Road Safety Audit Stage 1

**Access to New Keystone Centre, Eldon Way,
Littlehampton**

Road Safety Answers reference no: RSA503

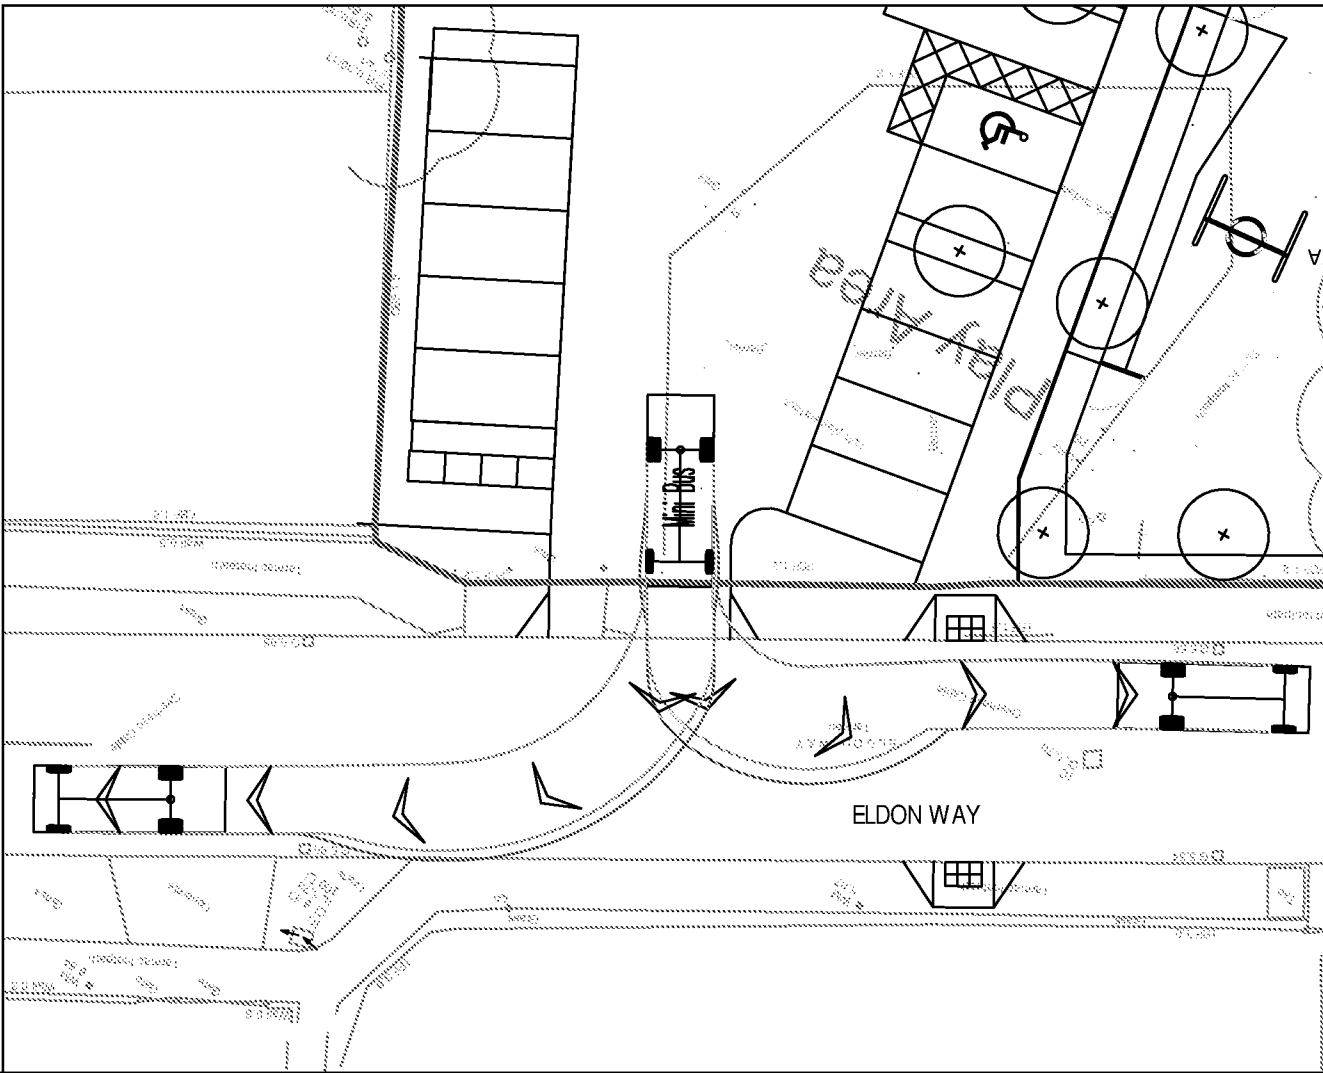
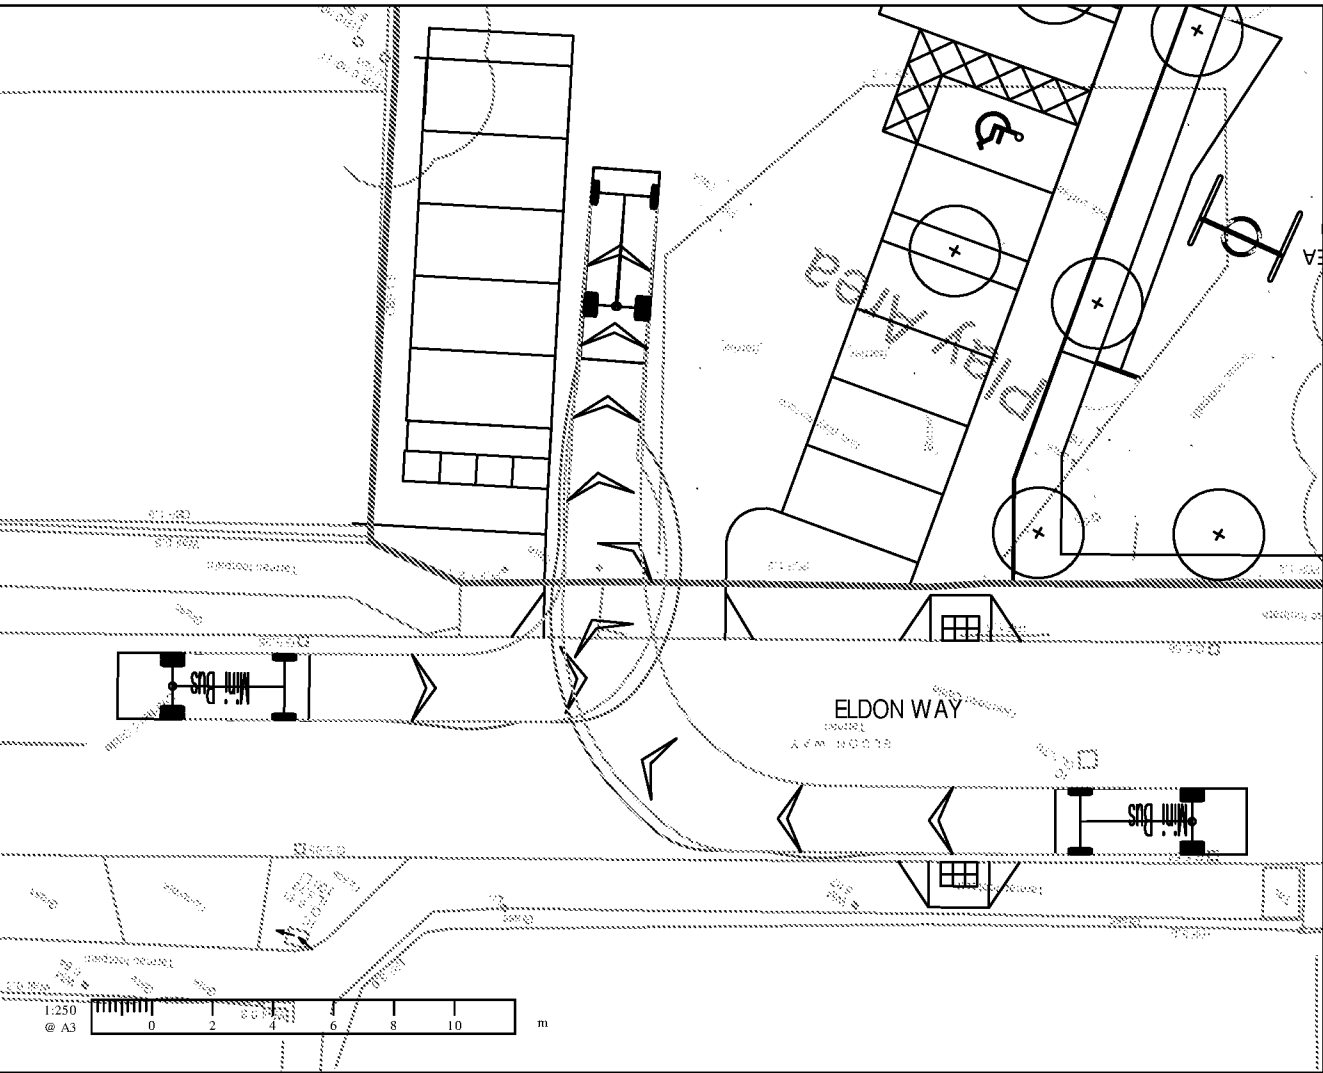
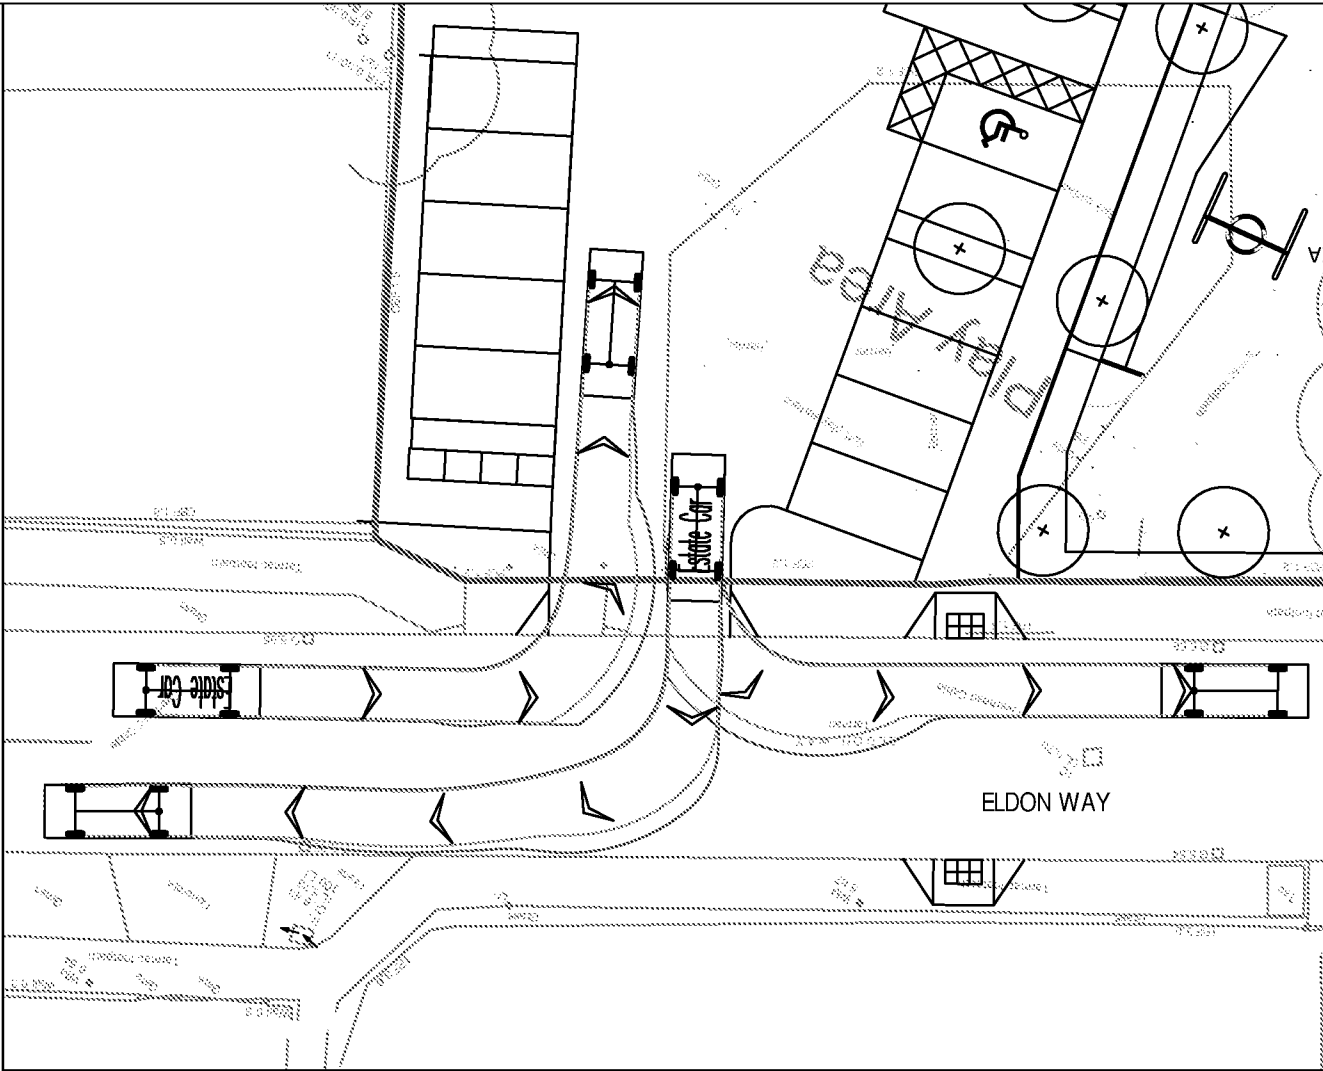
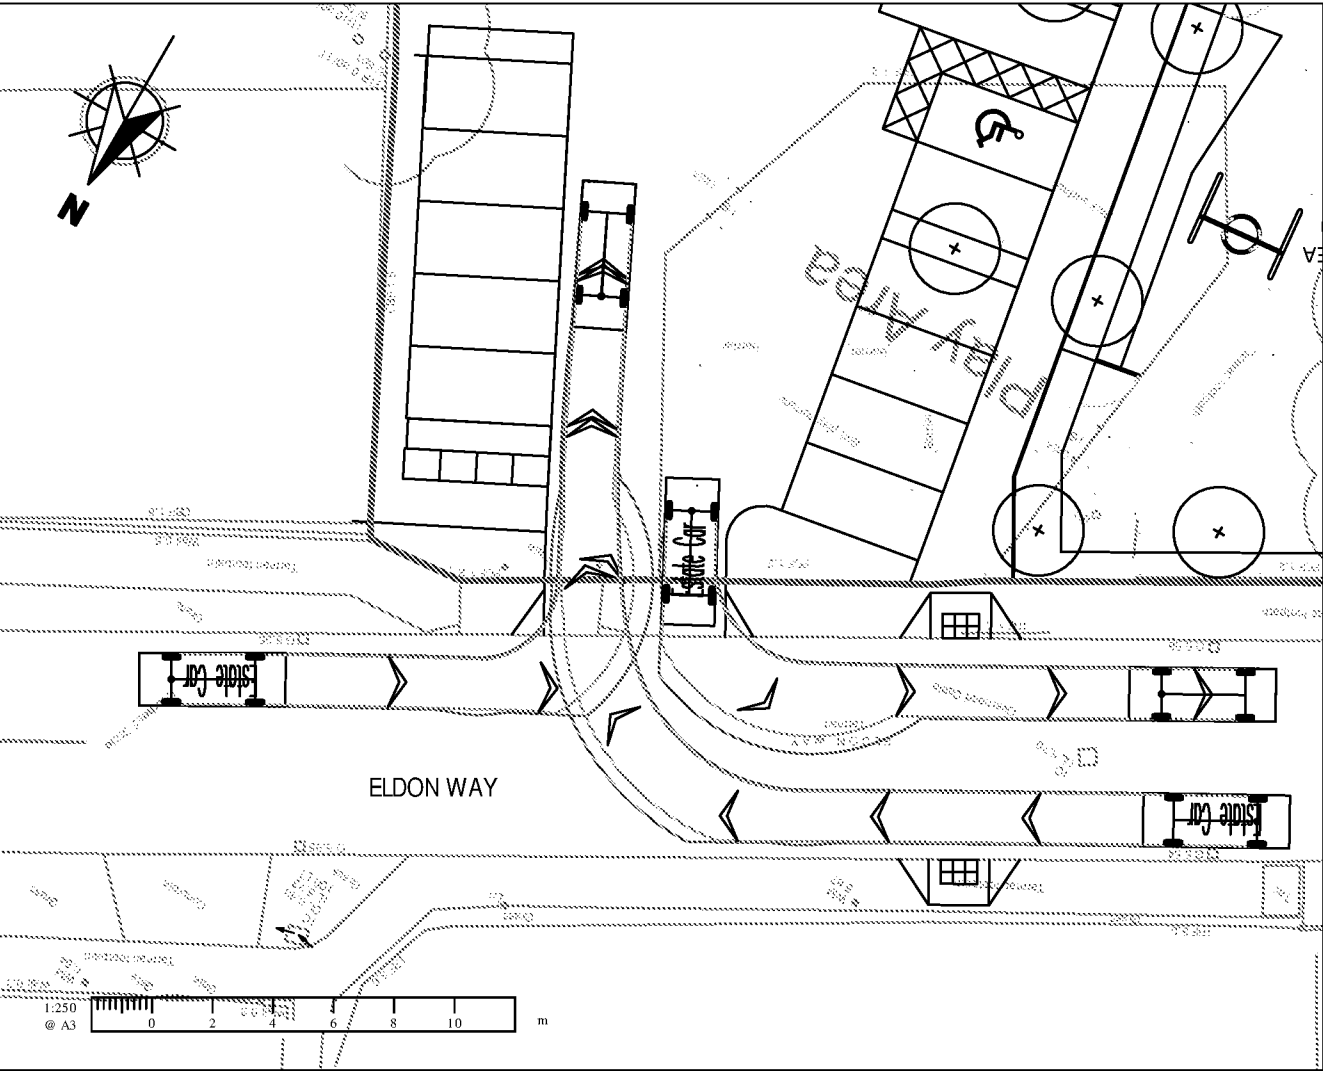
Location: A – Eldon Way at the uncontrolled pedestrian crossing and vehicular access.

Summary: Risk of collisions between passing traffic, vehicles leaving the car park and pedestrians using the uncontrolled crossing.

The Keystone Centre is located at the edge of a light industrial area and a residential area, Eldon Way being an industrial standard road, 7.3m in width. As a result, vehicles relating to the industrial use sometimes park along Eldon Way. Photo 1 shows a cherry picker light goods vehicle parked approximately where the uncontrolled pedestrian crossing is proposed. The road is wide enough for vehicles to park on each side, allowing a single lane in the middle through which opposing vehicles have to give way to one another. If this parking coincides with the opening hours of the Keystone Centre on each side of Eldon Way, pedestrians will have to cross between parked vehicles, their inter-visibility with approaching traffic compromised, increasing their risk of collisions with such traffic. Vehicular movements to and from the proposed access will also be difficult, inter-visibility with approaching traffic again compromised, increasing their risk of collisions.

The uncontrolled pedestrian crossing, and the proposed vehicular access, should be kept clear of parked vehicles using suitable measures, perhaps by extending the waiting restrictions at the junction of Eldon Way and Clun Road and converting them to At Any time waiting restrictions.

Problem no.	Problem Accepted (yes/no)	Recommended Measure Accepted (yes/no)	Design Organisation Response	Over Seeing Organisation Response	Agreed RSA Action
2.1	Yes	Yes	Recommendation enhanced to double yellow lines to ensure that no parking takes place in the vicinity of the proposed vehicle crossover and pedestrian crossing facilities. The existing single yellow line TRO is active between the hours of 8am – 6pm Mon – Sat, this would not necessarily coincide with proposed operating hours.
